Application No: M/98/25/HH
Site Address: 1 Elmer Court Elmer Middleton-on-sea PO22 6JT
Description of works: Extension and alterations to form a rear facing balcony and sliding doors (part retrospective).

Thank you for your internet representation made on 4th February 2026 which has been recorded as an objection with the comments as follows:

06 SIDE (EAST) ELEVATION:

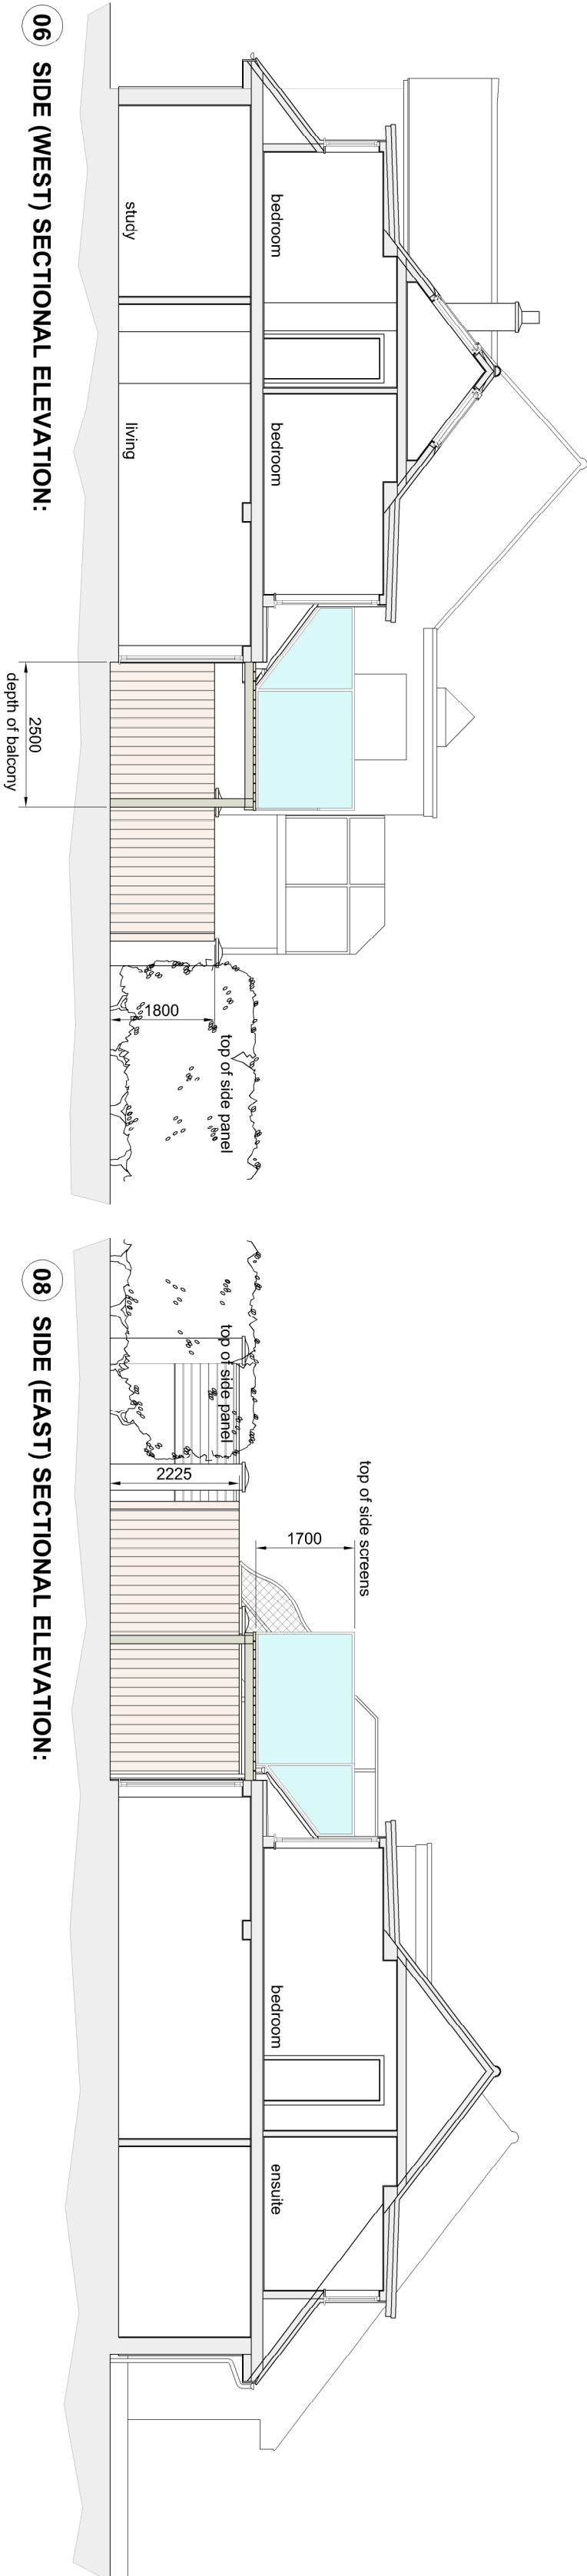
The proposed balcony sets a precedent in that it goes right across the house .
I would be concerned that the neighbor's either side of 1 Elmer court would have some loss of privacy
